Appeal Decision

Appeal Ref: 6001572

37 Bradford Road / 2 & 4 King Street, Cleckheaton BD19 3JN

PROPOSED PLANS Scale 1.100

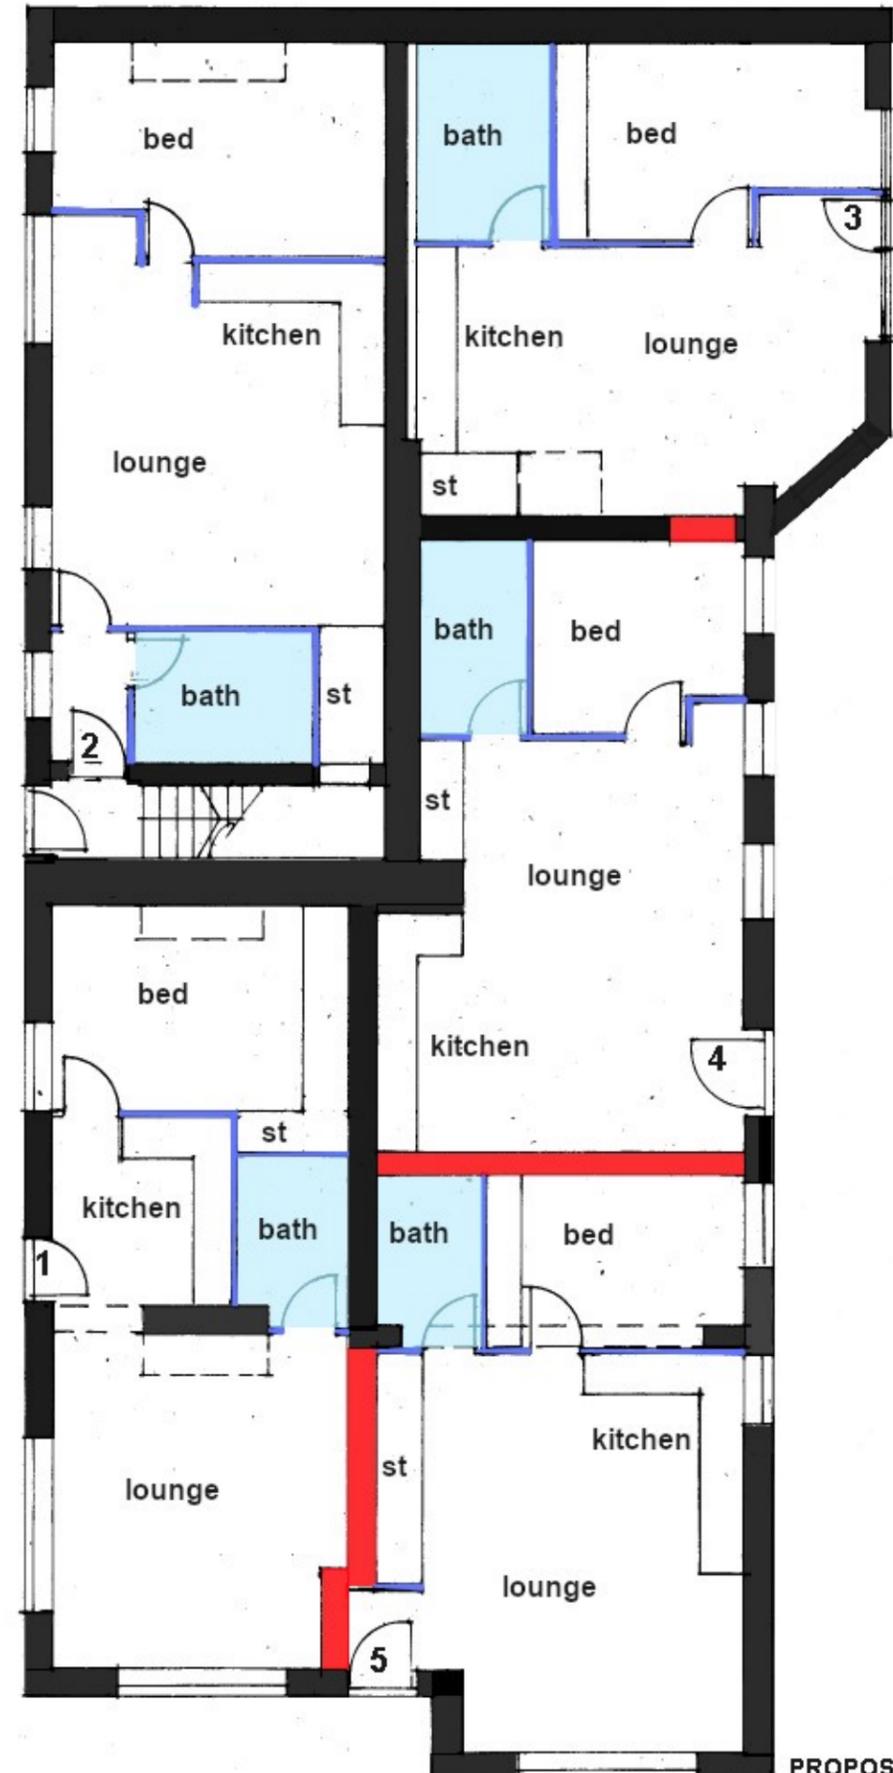
16. The appeal building has a 3 storey building in its proximity to the south, and a 1.5 storey building to its north. The plans show that all habitable rooms of the proposed flats would be served by windows.

17. Due to a combination of the proposed layout, proximity to neighbouring buildings, and orientation, it is not clear that adequate natural light could be achieved for all habitable rooms. This particularly concerns flat 2 (ground floor), flat 7 (first floor), and flat 3 (ground floor) as they would be located towards the rear of the appeal building, opposite the 3 storey neighbouring building (flats 2 and 7), and opposite the 1.5 storey adjoining building (flat 3).

18. In the absence of substantive evidence, such as a Natural Lighting Assessment for the appeal scheme, I conclude that it has not been demonstrated that the proposed development would provide adequate natural light in all habitable rooms of the proposed flats and the proposed development would, therefore, not meet the requirements of MA.2. (2) (f) under Class MA of the GPDO.

8. The appeal site lies within a town centre location with access to public transport. The submitted plans show that the appeal site boundary extends beyond the footprint of the building to include part of King Street and land immediately to the north, adjoining the neighbouring car wash/garage. Based on my site visit observations, the land to the north appears to function as an access track leading from Bradford Road to a gated area situated to the rear of the appeal building. King Street also leads from Bradford Road to a gated area to the rear of the appeal site.

9. The limited information provided at the application stage includes no details regarding refuse storage and collection arrangements, cycle parking provision, or whether any off-street parking facilities would be available. In the absence of substantive information demonstrating how the development would be accessed and serviced, I am unable to conclude that the scheme would operate safely or that its overall transport effects would be acceptable.
